Engineers Comments Regarding Surface Water Drainage

Application No: AL/37/20/DOC

Site Address: Forge House Nyton Road Westergate PO20 3UP

Grid Reference: 494185 105564
Description of Works: Approval of details reserved by condition imposed under ref APP/C3810/W/1/3213581 (AL/129/17/PL) relating to Condition No 3 - surface water drainage

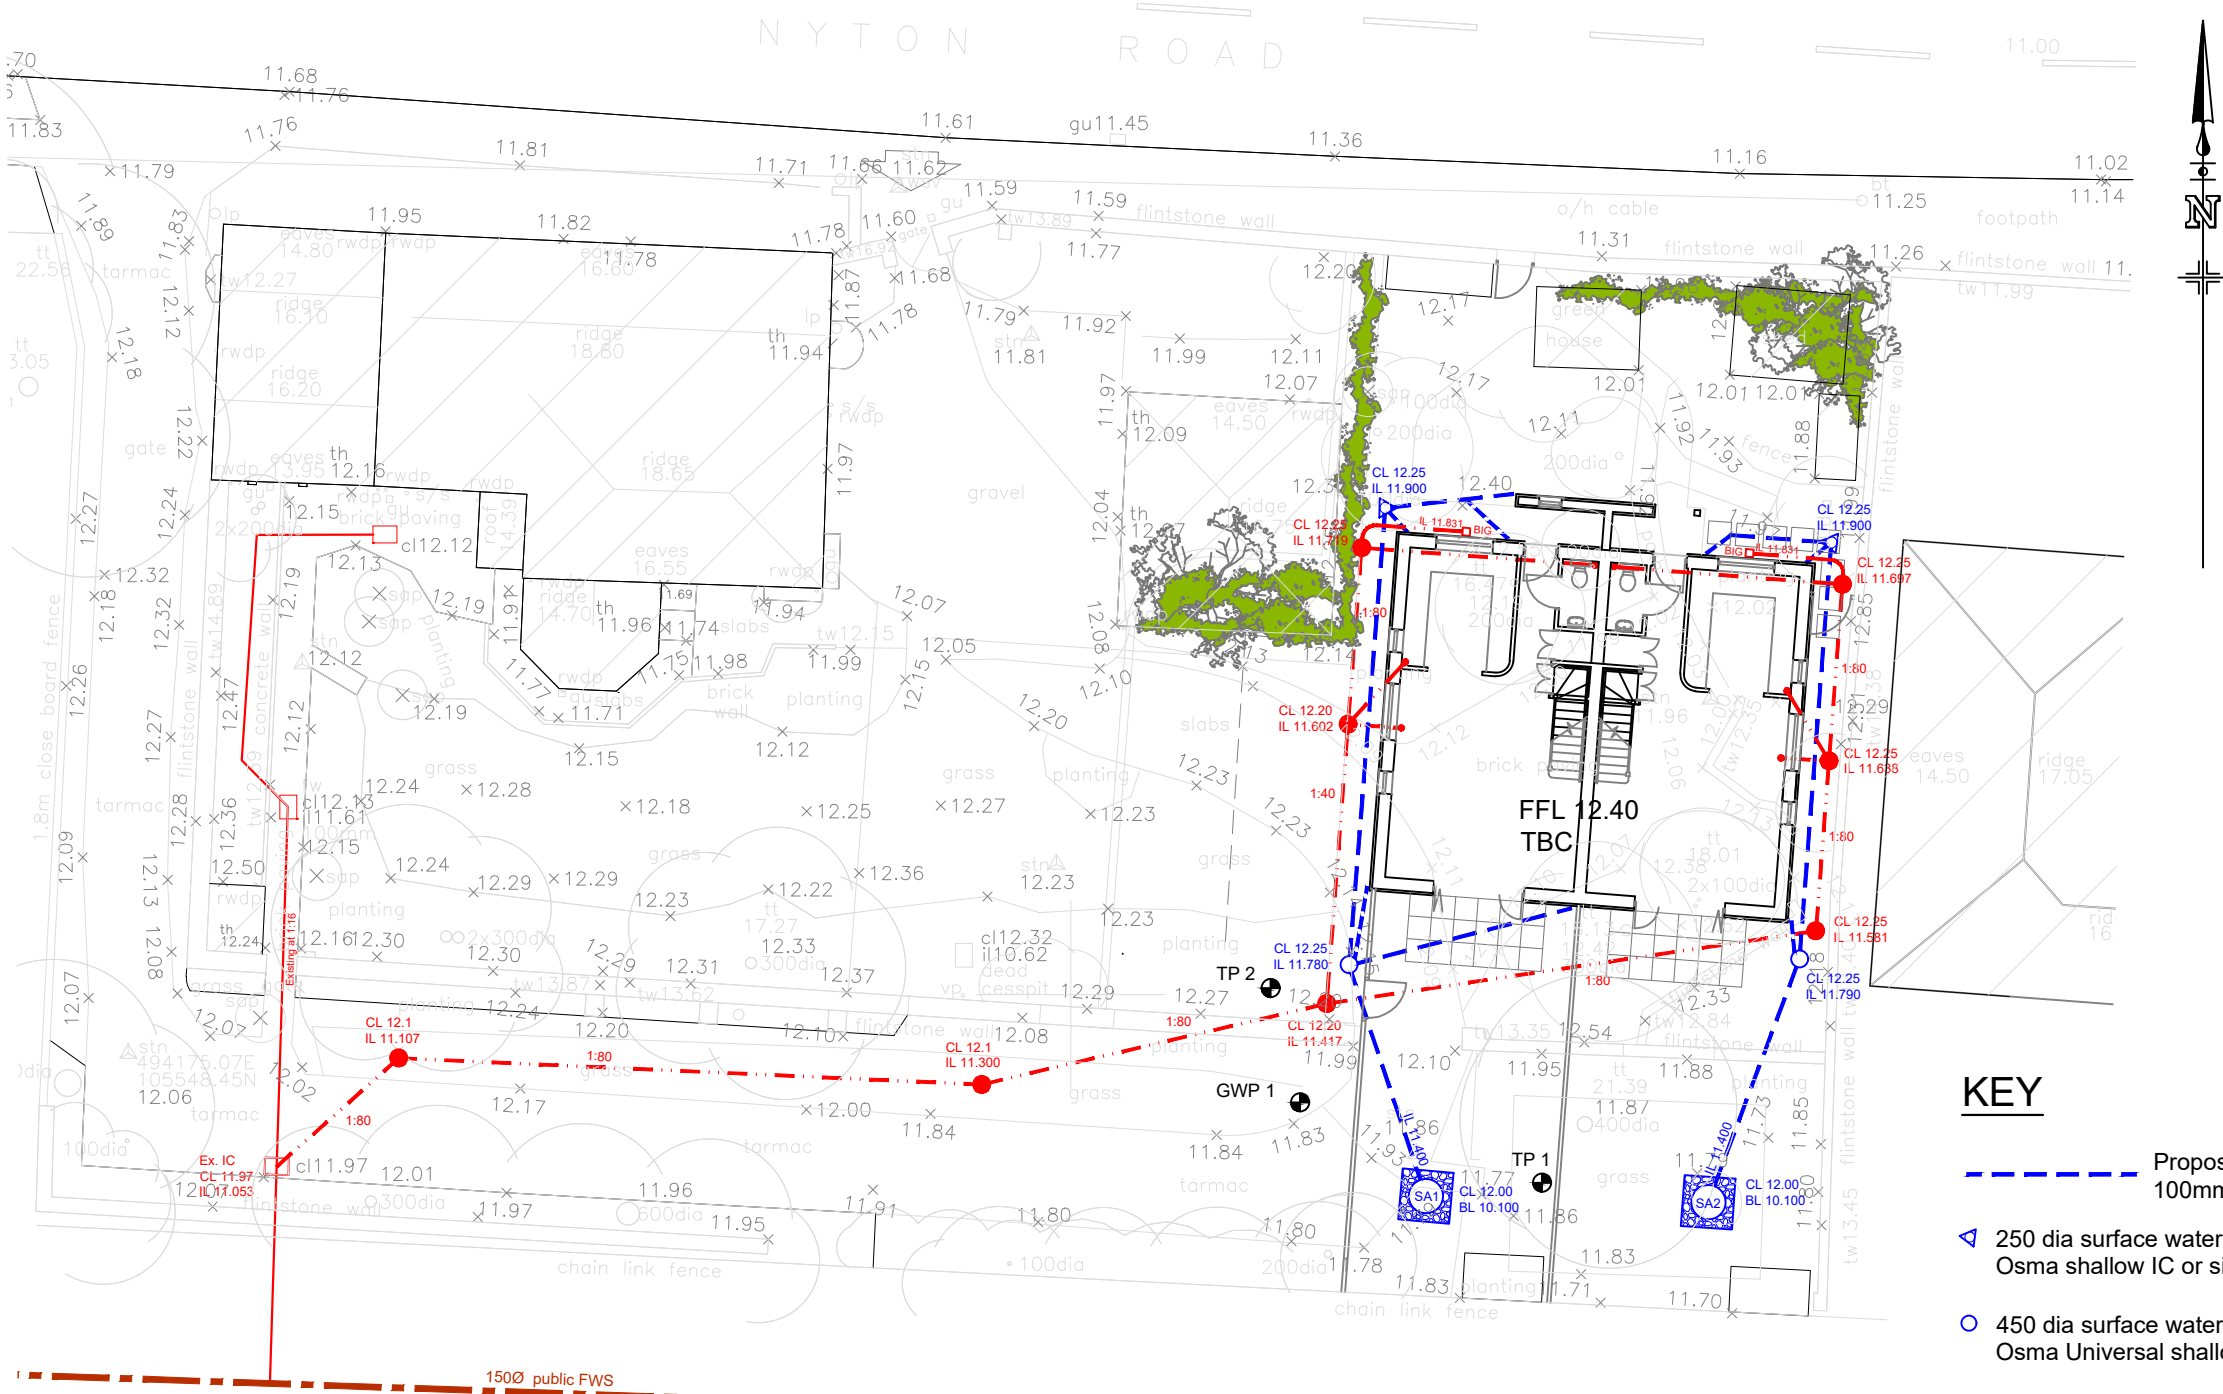
1. Please provide silt traps (or sumps on inspection chambers) upstream of the soakaways. Whilst it is acknowledged that the concrete ring soakaways are accessible for clearance, silt traps are easier to clear.
2. Please provide a construction detail for a concrete pipe bed and surround for where pipe depths are less than 900mm. Plus amend note as to when each surround should be used (Granular where cover to crown

3. Please provide a construction detail for the inspection chambers, and silt traps (see point 1).
4. Please confirm the dimensions of the trial pits within the Surface Water Drainage Notes.

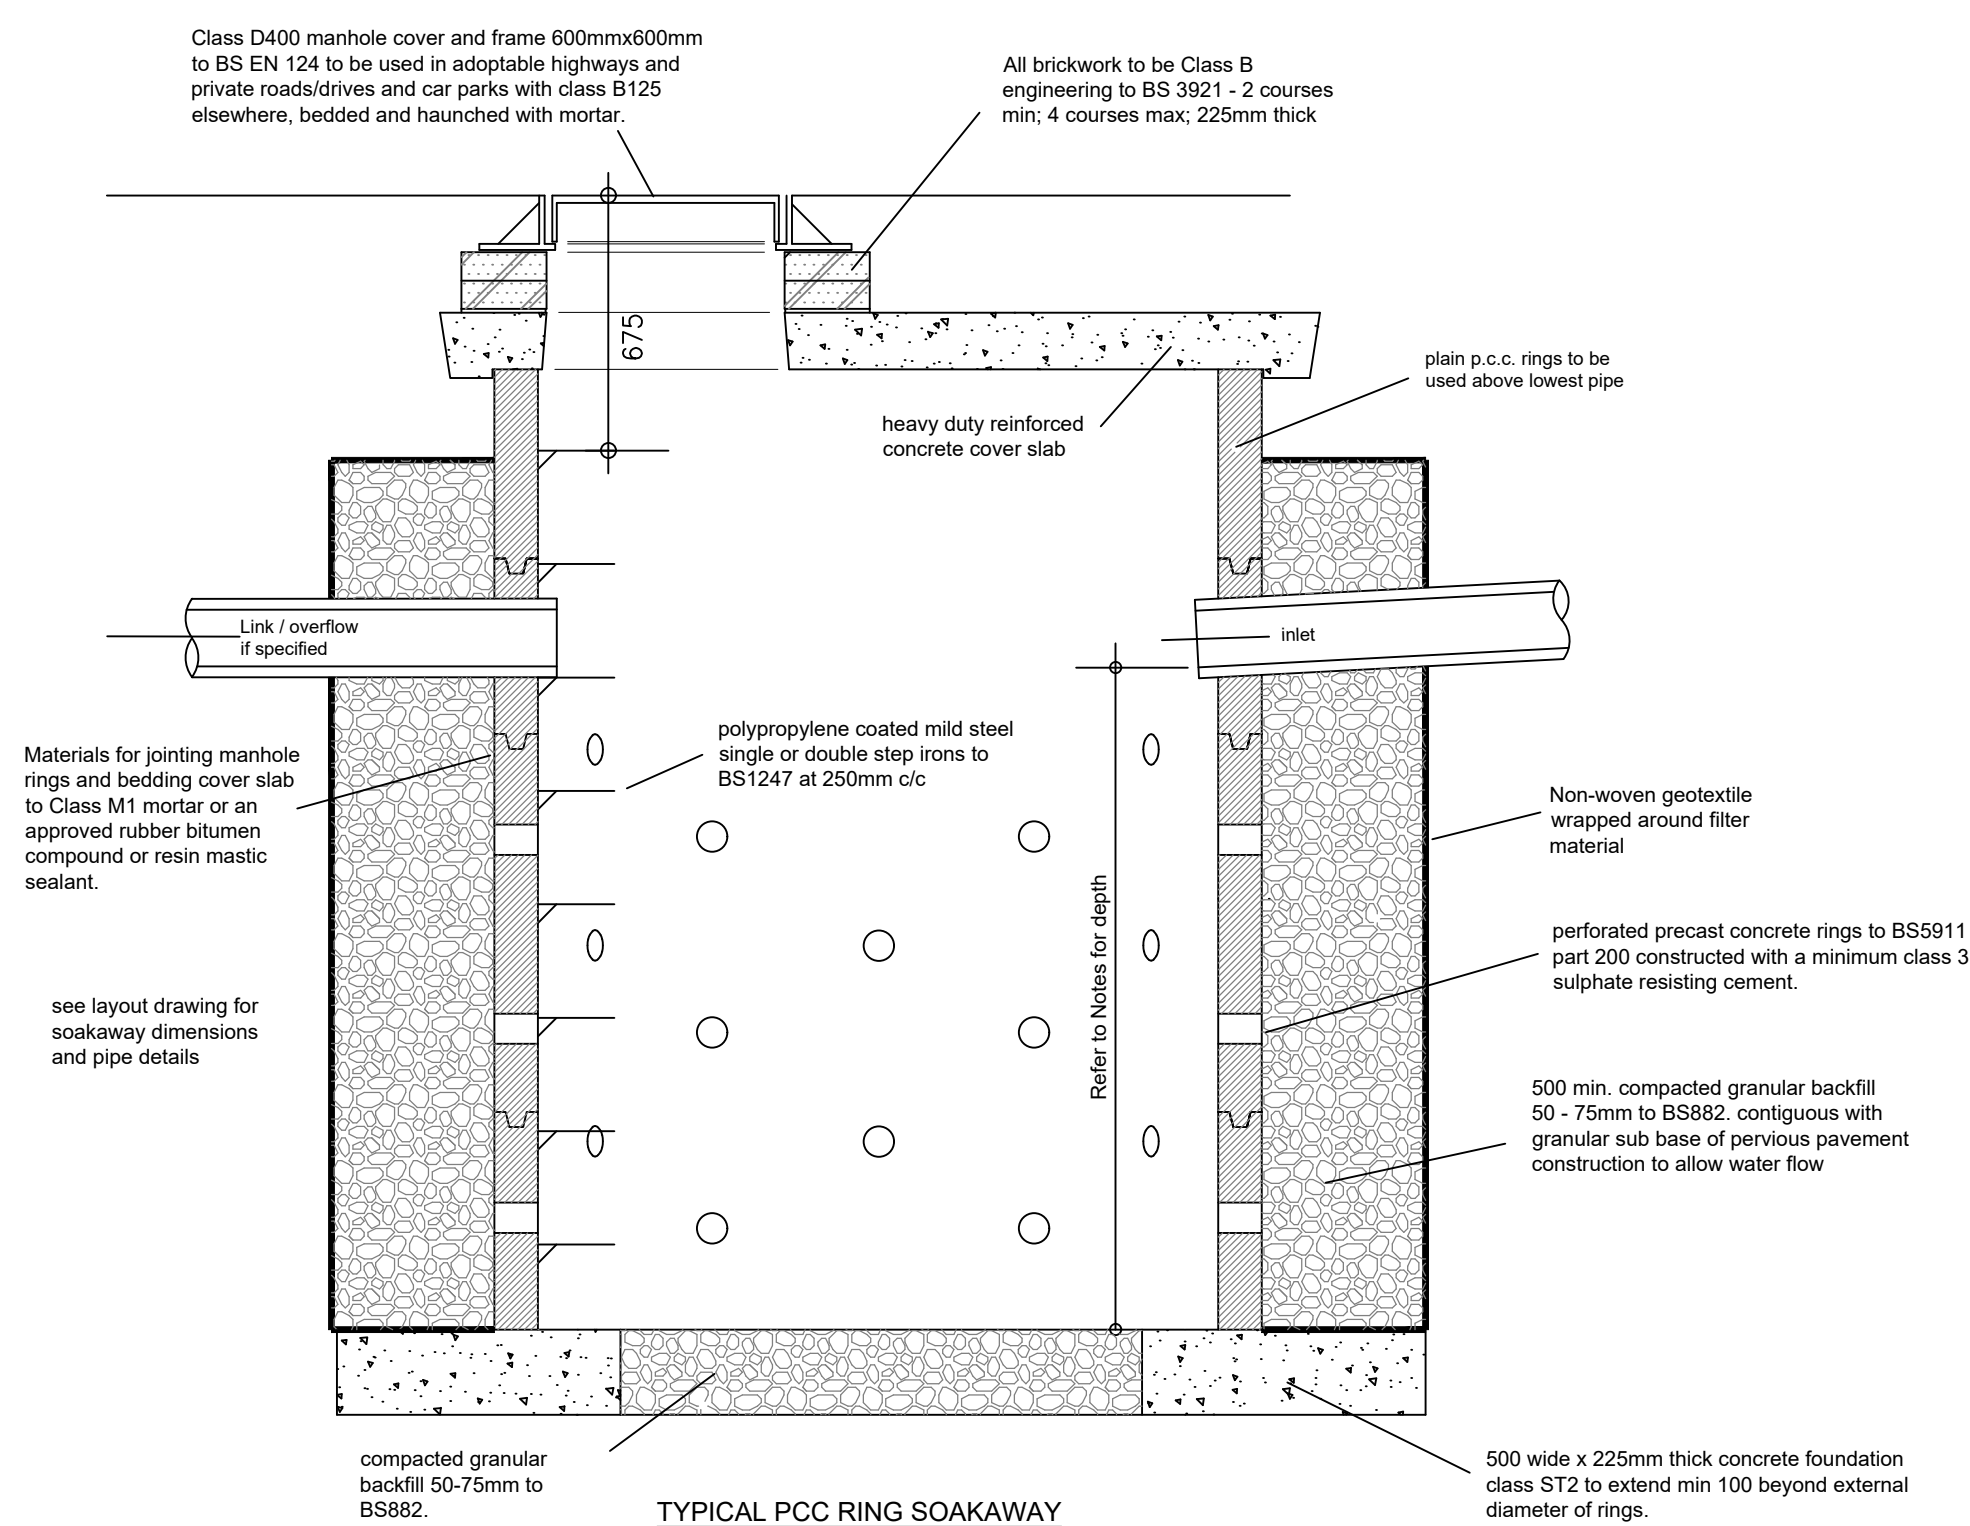
is greater than 1200mm in vehicular areas, or greater than 900mm elsewhere. For shallower depths concrete surround.)
